Application for Removal or Variation of a Condition following Grant of Planning Permission or Listed Building Consent

Erection of single-storey lean-to side extension, alterations to fenestration, internal alterations and associated works at Littons Church Lane Naunton Cheltenham Gloucestershire GL54 3AT

23/01654/FUL

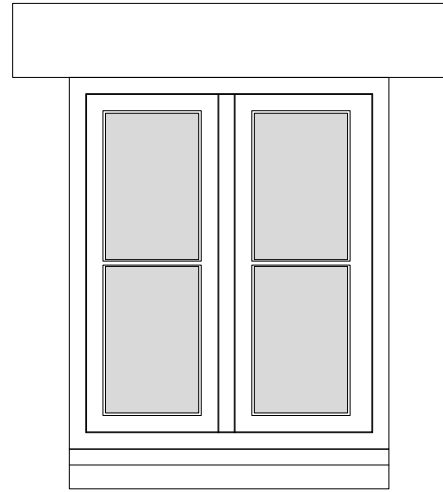
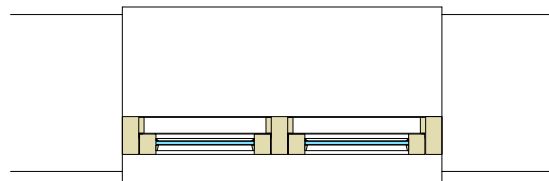
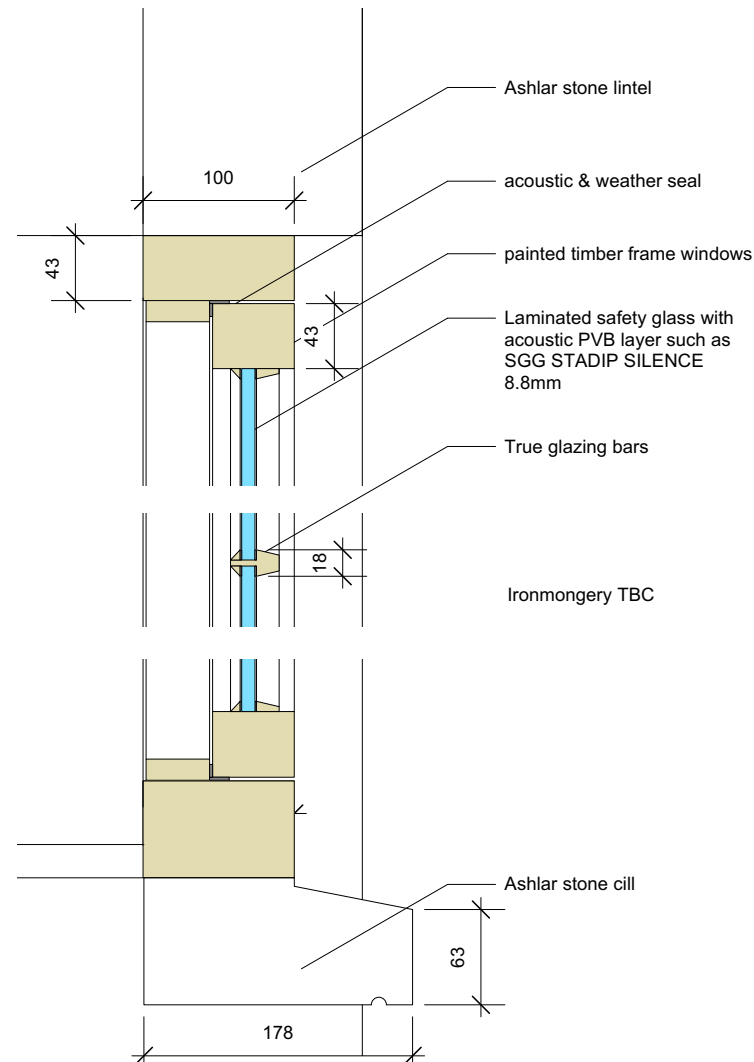
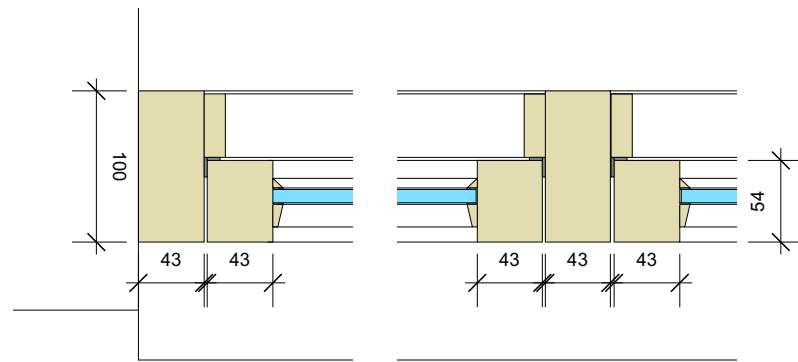
To allow for the new laundry partition location, central external door proposed changed to two smaller windows matching existing.

The development hereby approved shall be carried out in accordance with the following drawing number(s): 22.06.03.15 REV H; 22.06.03.16 REV D; 22.06.03.18 REV F; 22.06.03.19 REV F; 22.06.04.23; 22.06.04.24; 22.06.04.32 REV A; 22.06.04.33; 22.06.04.34; 22.06.04.35; 22.06.04.38. 22.06.04.30 REV A, 22.06.04.36 REV A; 22.06.04.39; 22.06.04.40; 22.06.04.41

DRAWING NUMBER 22.06.03.15

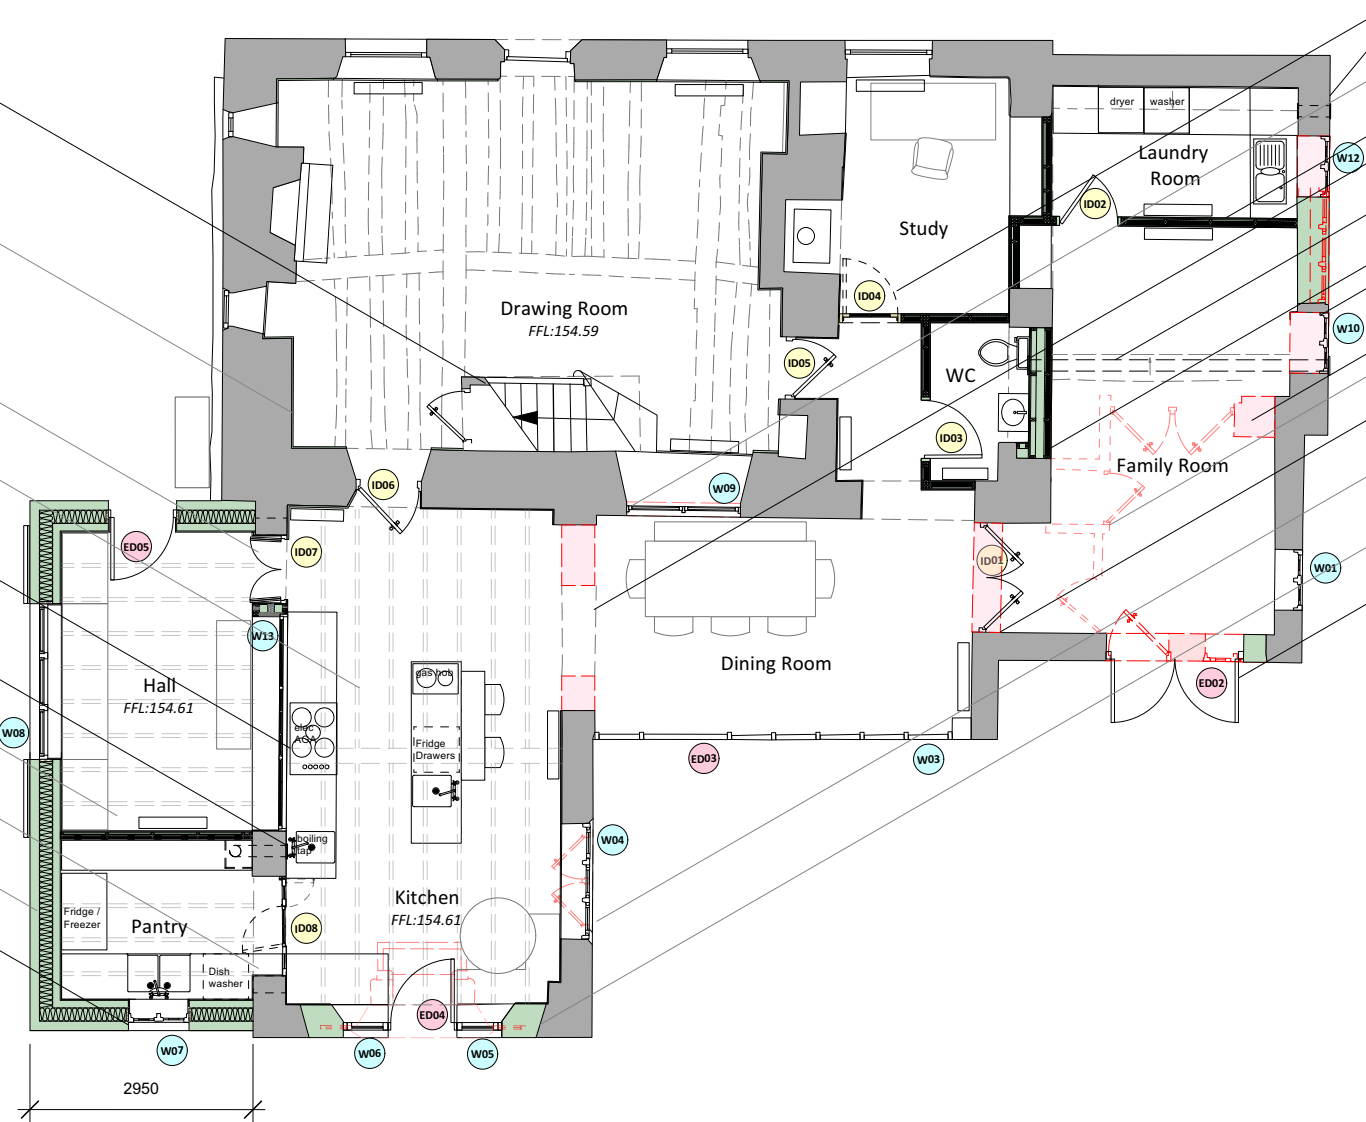
To allow for alterations to the location of new partitions internally which will allow for better supervision of children across the ground floor. (WC, Family Room & Laundry locations).

To allow for new and wider openings to internal walls between the less historic parts of the house at the rear, to let more light through the property and for better supervision of children across the ground floor.

To allow for better access into the garden from the Family room, new double doors in place of the existing door and window, for better supervision of children across the ground floor and garden and more internal natural light to the Family room.
